STATE OF NORTH CAROLINA
DEPARTMENT OF TRANSPORTATION

Addendum No. 1

RE: Contract ID C202602

Iredell County (I-3819A)

PROJECT REFERENCE NO.	SHEET NO.
1-3819A	4
R/W SHEET NO.	5
ROADWAY DESIGN ENGINEER	HYDRAULICS ENGINEER
INCOMPLETE PLANS DO NOT USE FOR R/W ACQUISITION PRELIMINARY PLANS DO NOT USE FOR CONSTRUCTION

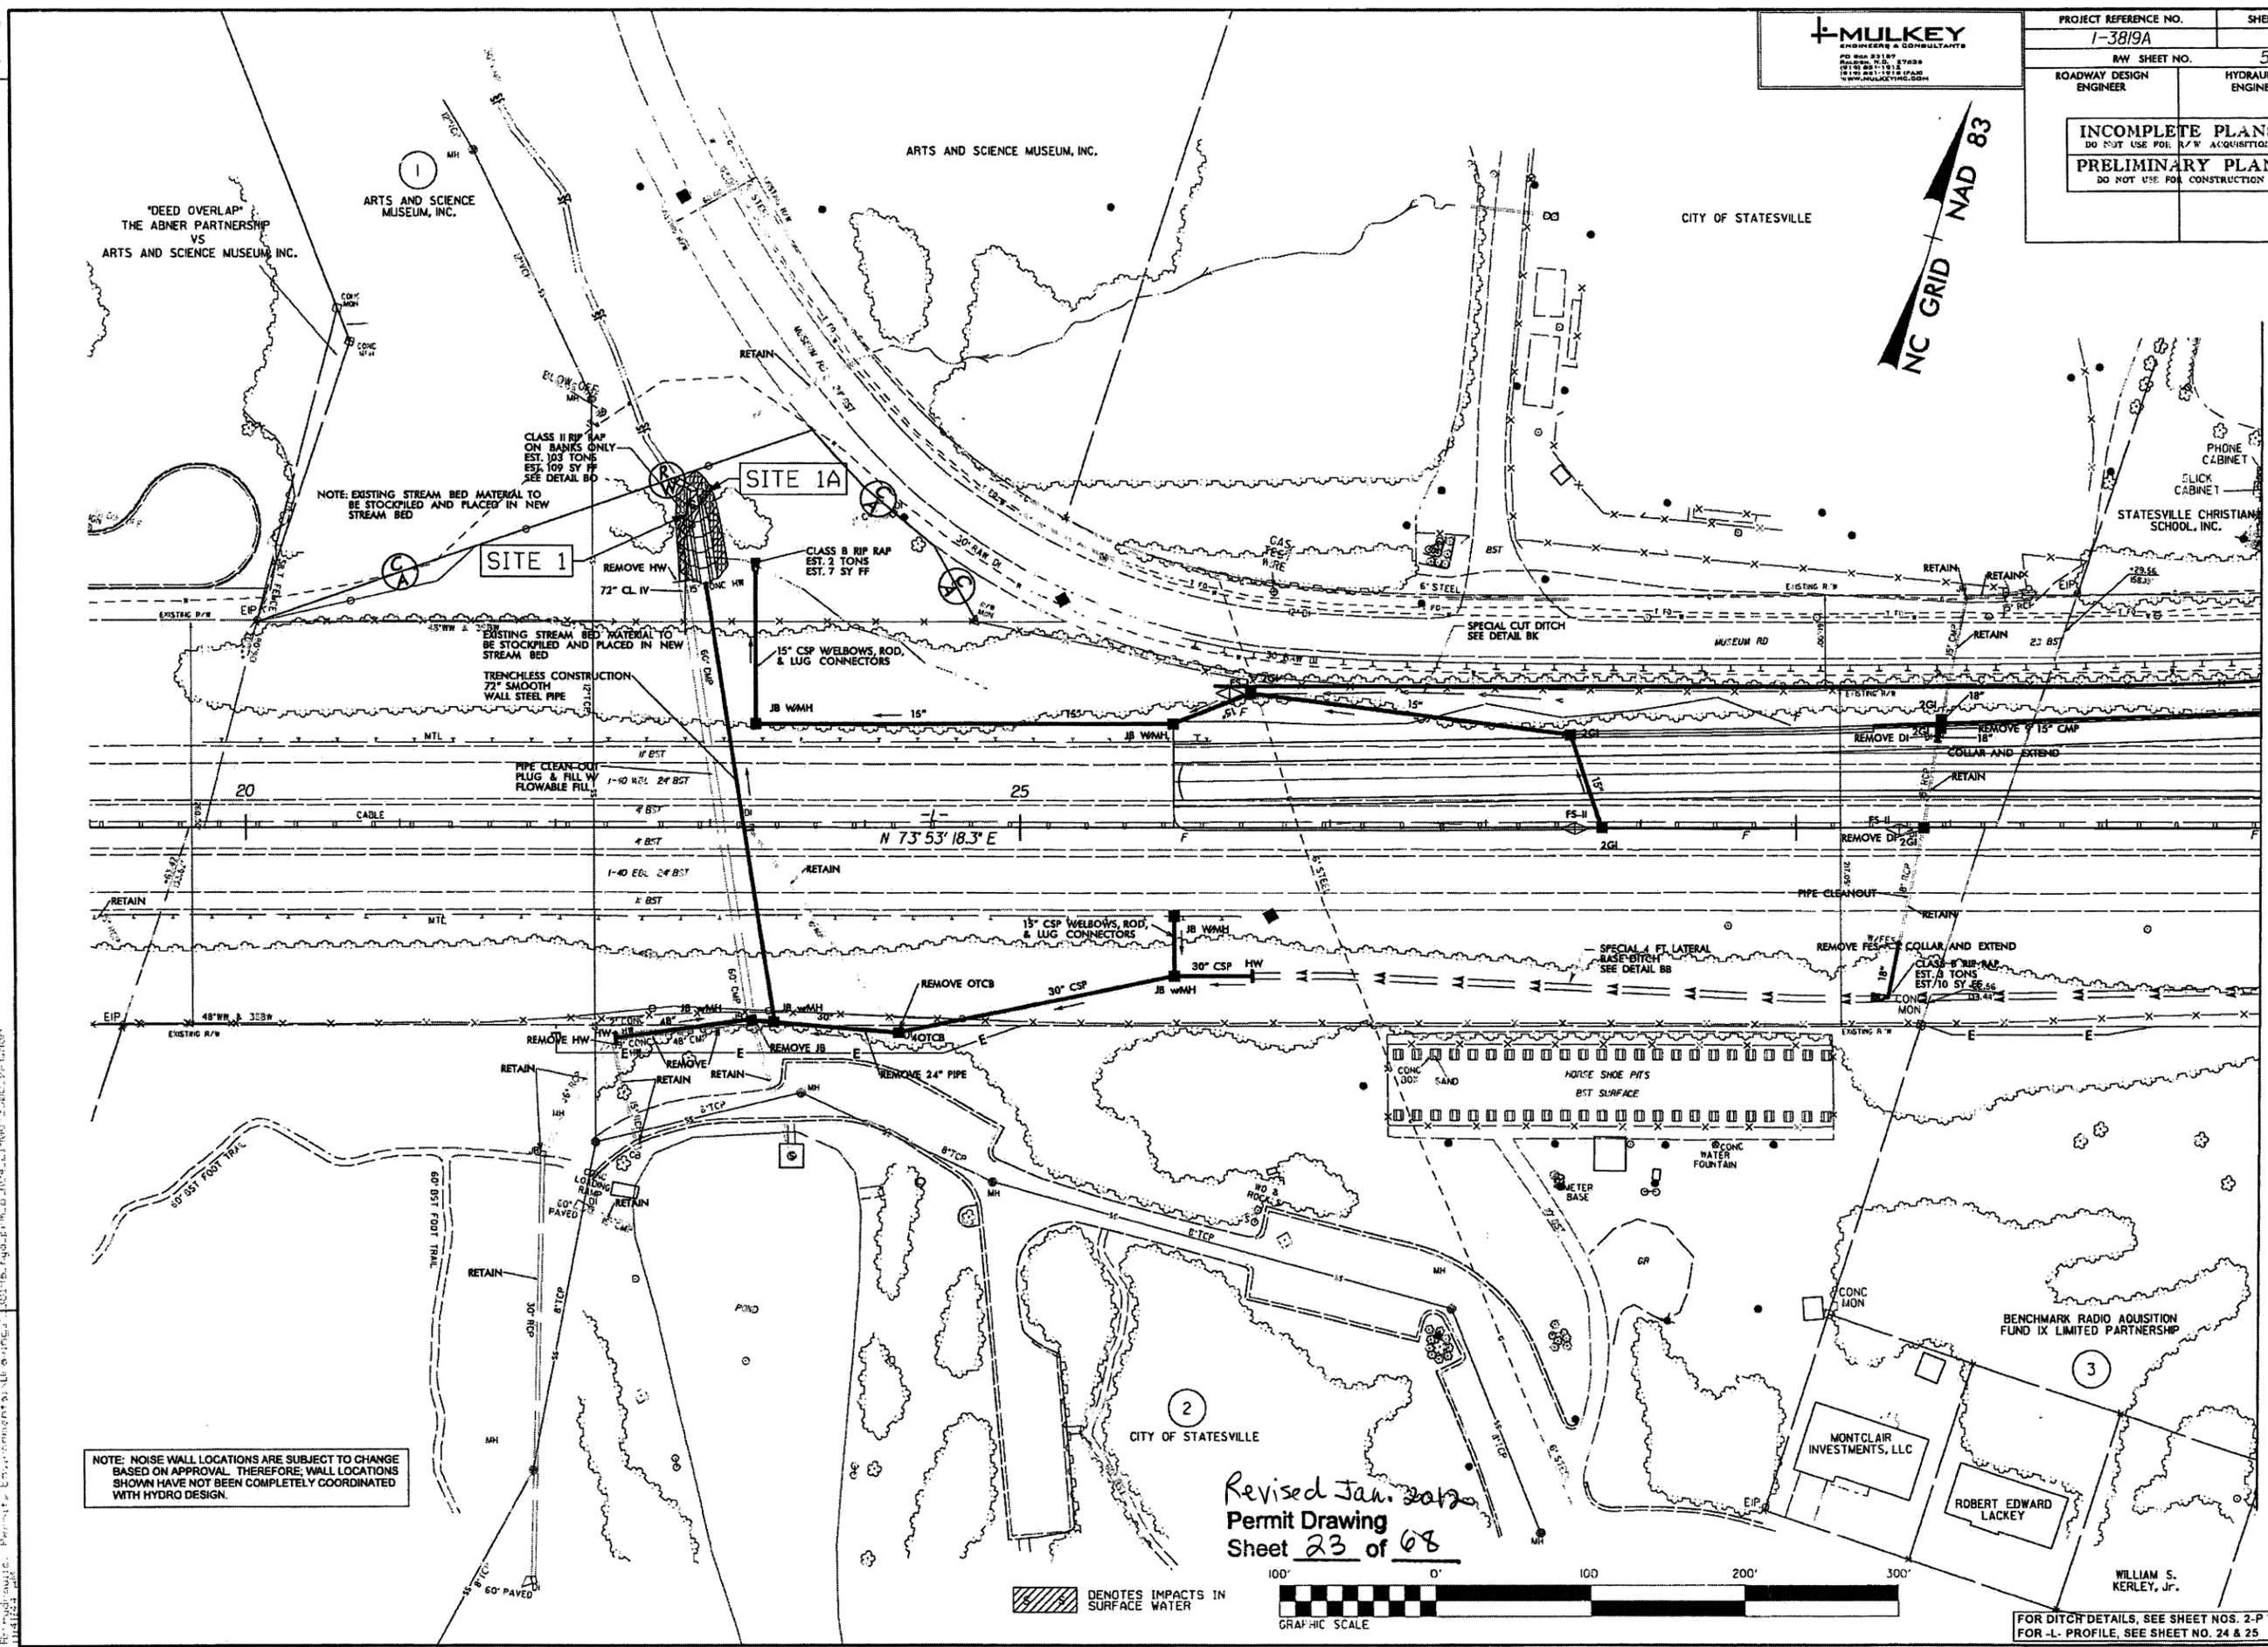
Sheet Nos. 4 and 5 have been revised to add "Noise Wall D" and to revise the necessary drainage features. Please void Sheet Nos. 4 and 5 in your plans and staple the revised Sheet Nos. 4 and 5 thereto.
